From: Gemma Kennedy [gkennedy@cravendc.gov.uk]
Sent: 01 May 2012 13:11
To: Jane Tucker
Subject: RE: Consultation on planning application 3/2012/0310 Pasture House Farm, West Marton, Skipton F.A.O. Graeme Thorpe

Please can we have your comments on the above planning application? It is for the proposed erection of a 50kw wind turbine on a 25m tower for business use, sited on agricultural land. I have attached the formal consultation letter and here is a link to view the application details on our website http://www.ribblevalley.gov.uk/site/scripts/planx_search.php

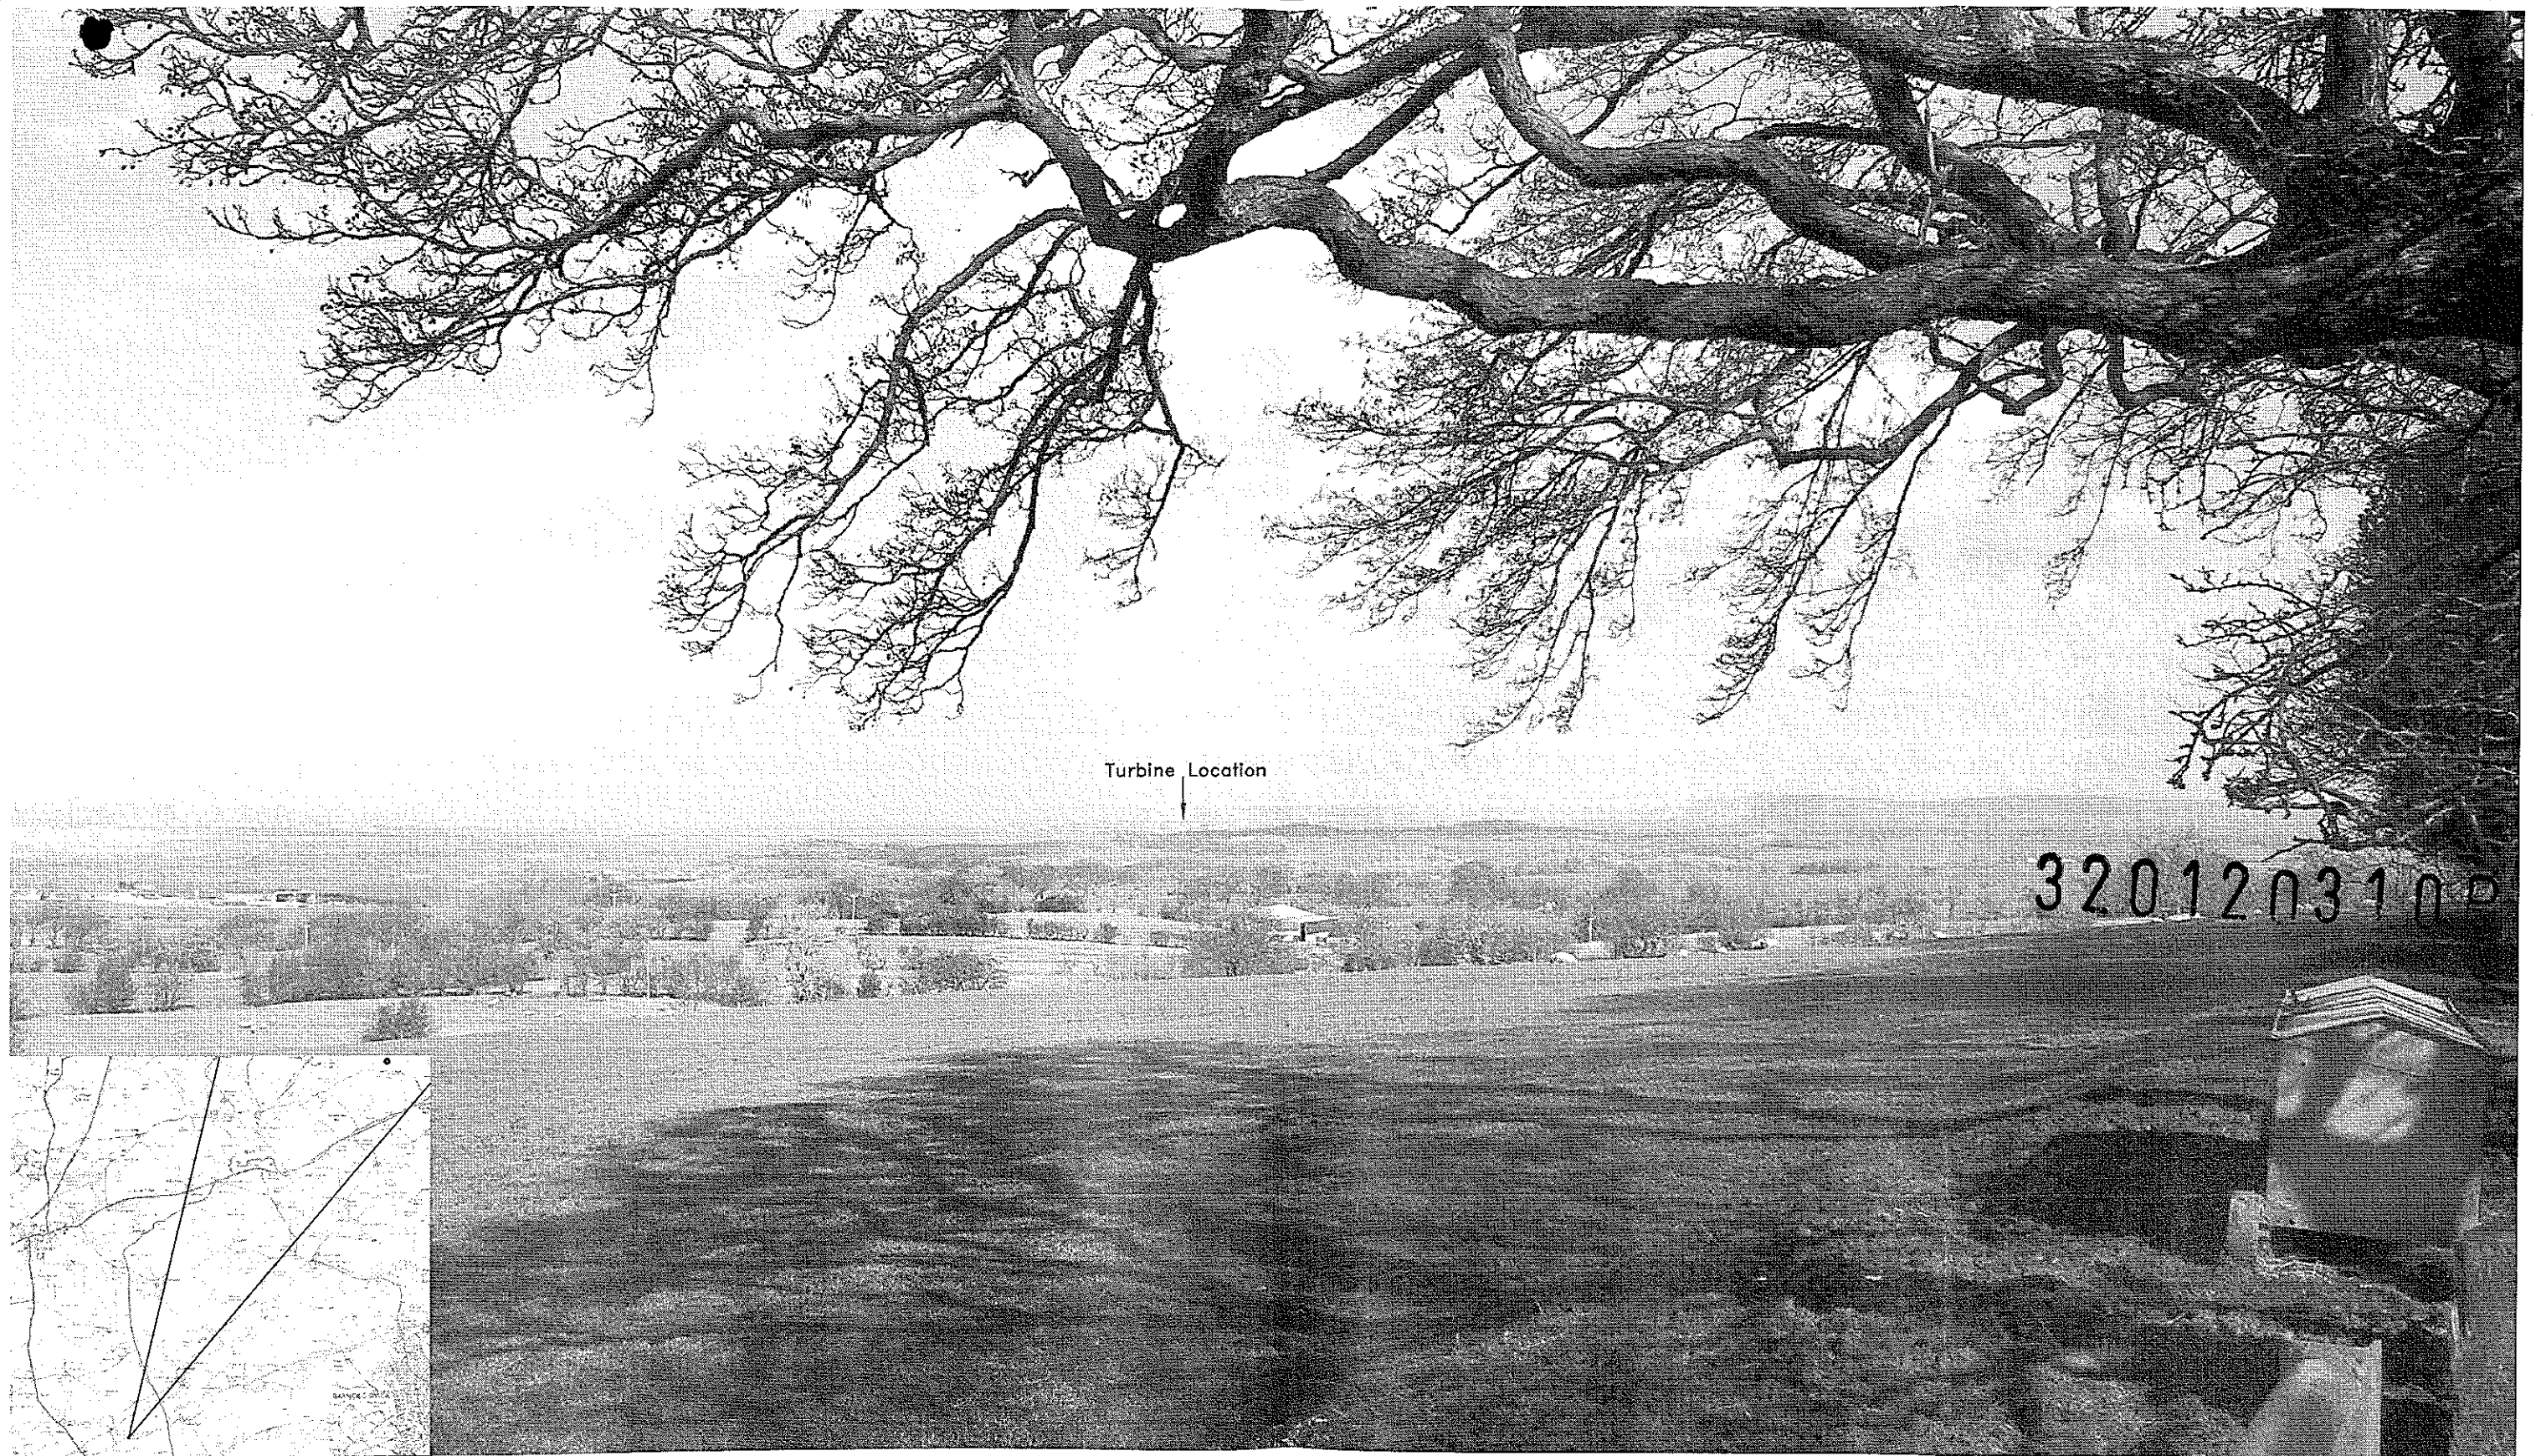
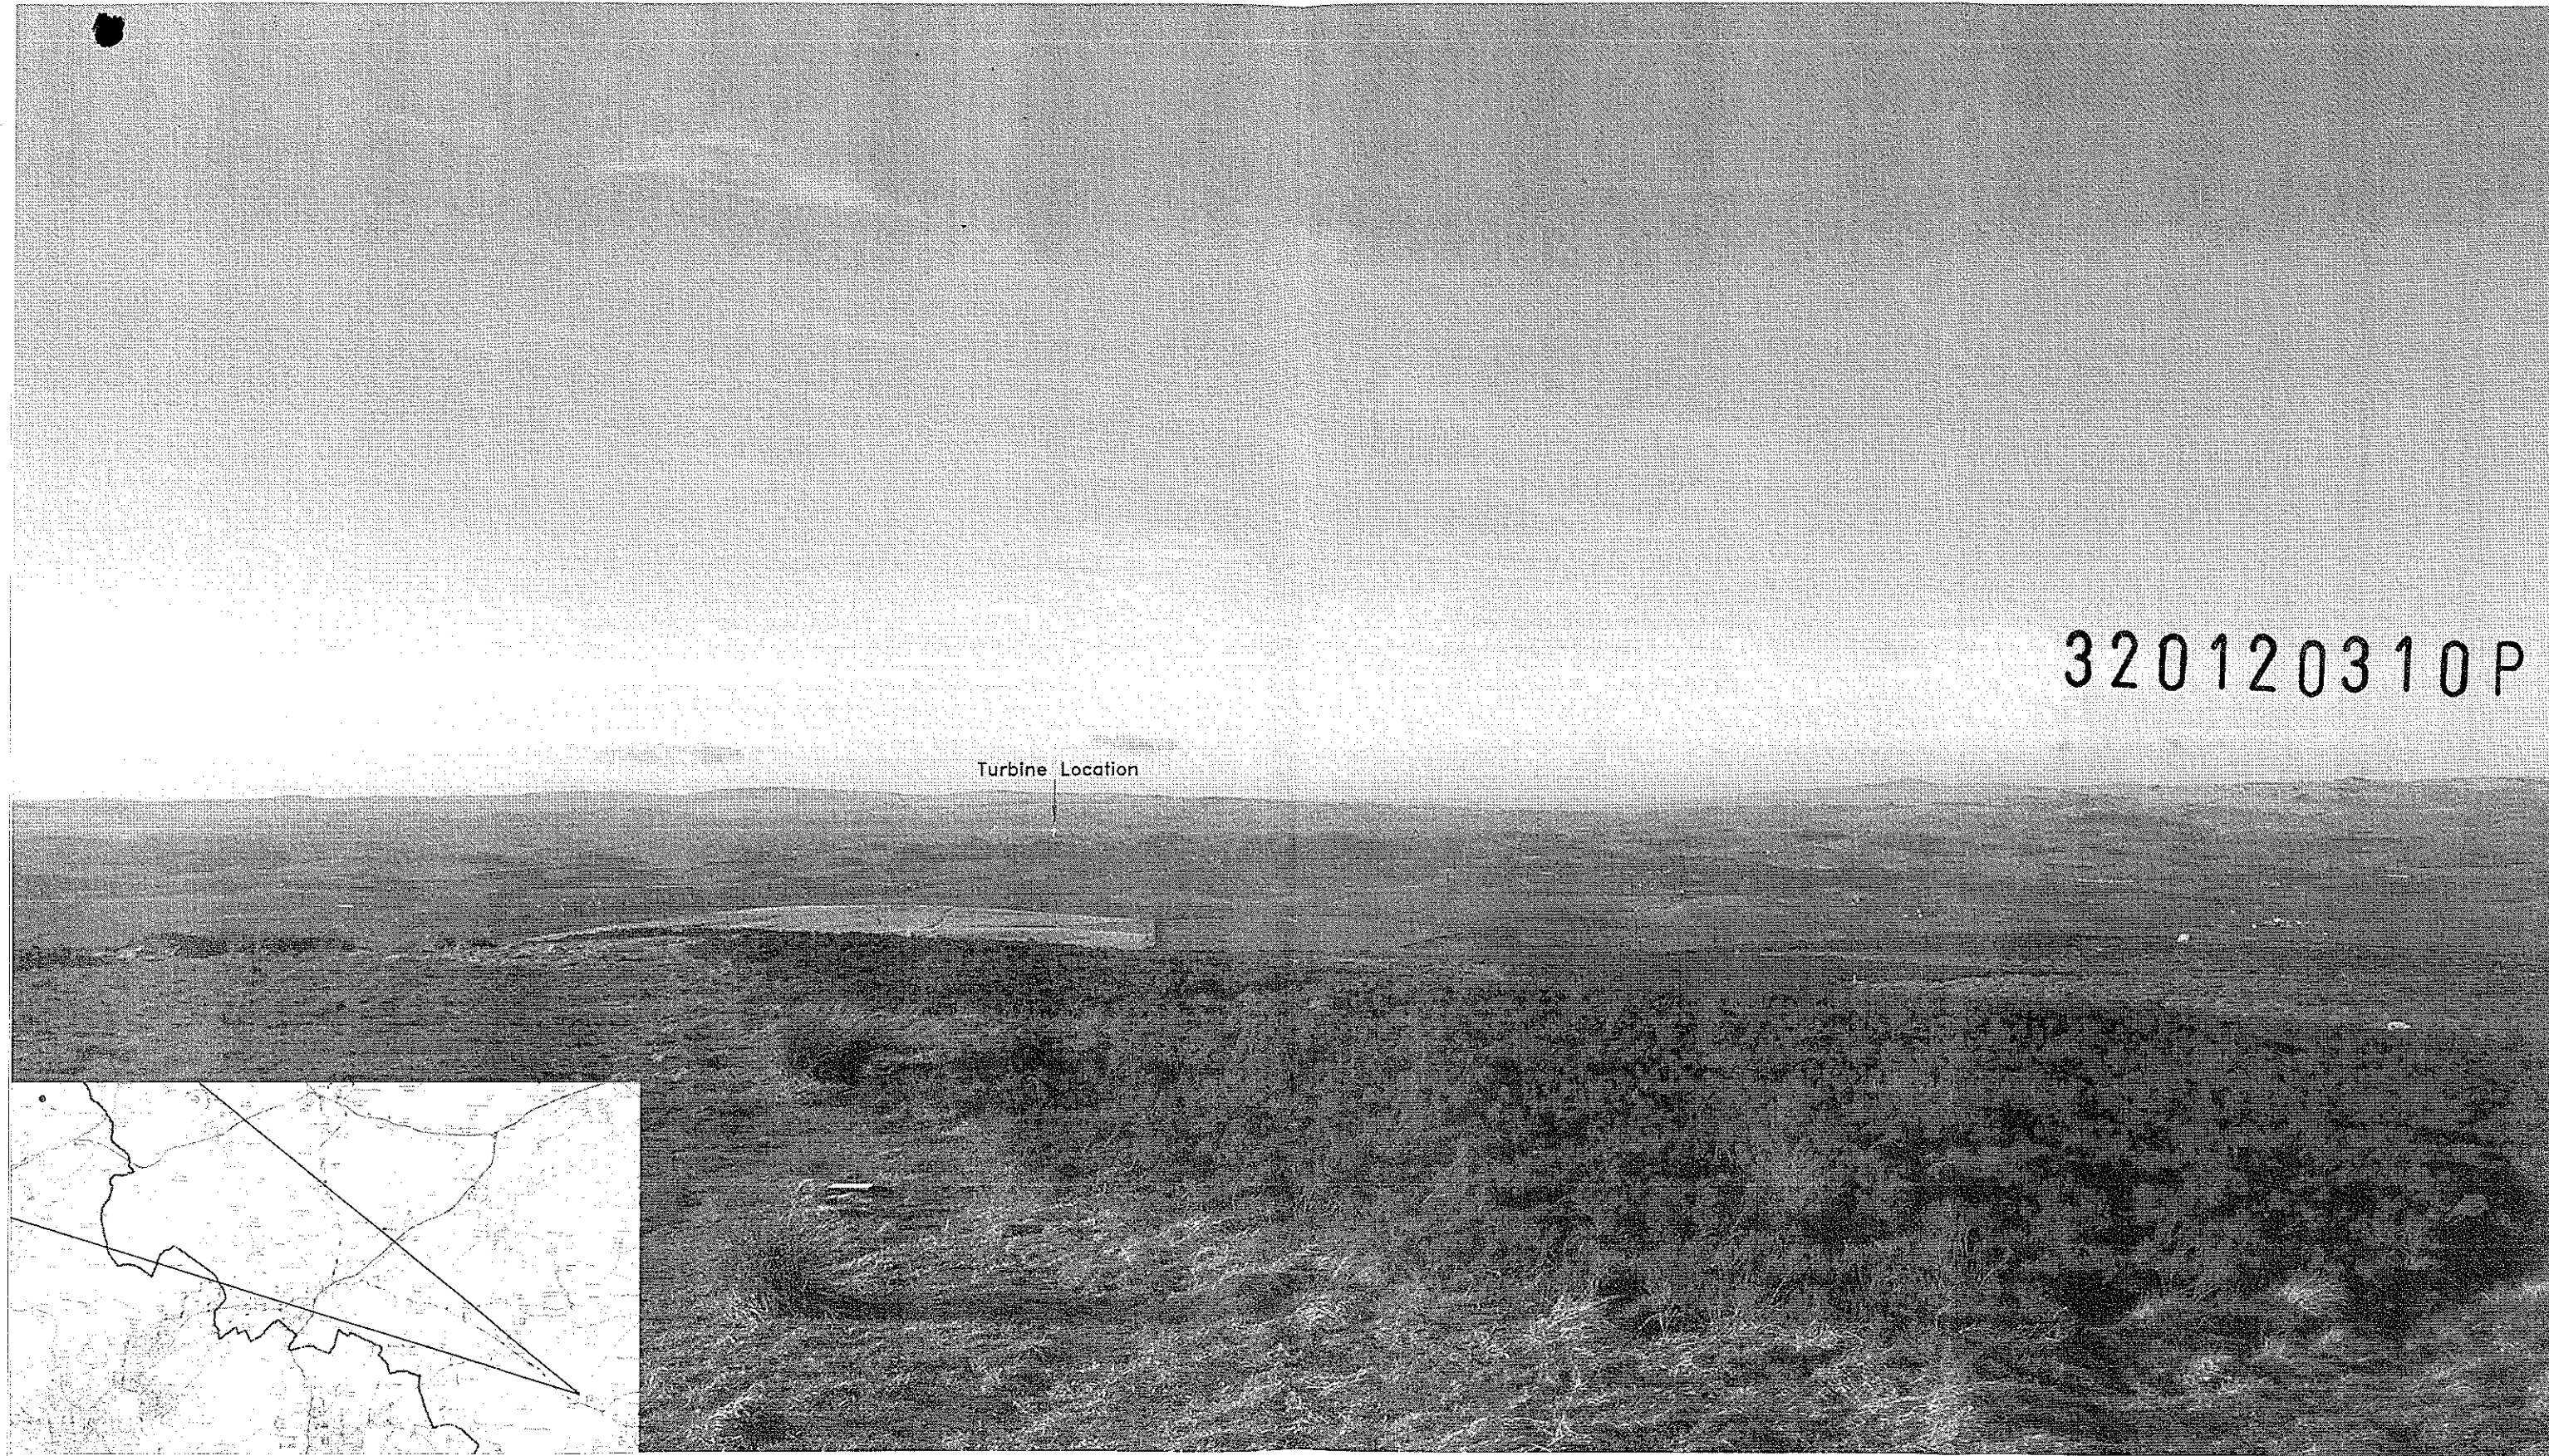
On another note, as the photomontages submitted with the application are shown in black and white/scanned in, on your website, it is very difficult to distinguish where the photographs are taken from and how the turbine would be viewed. Can I suggest that the original electronic copy is attached directly, or scanned in colour, in future applications so that consultees can see the information more clearly?
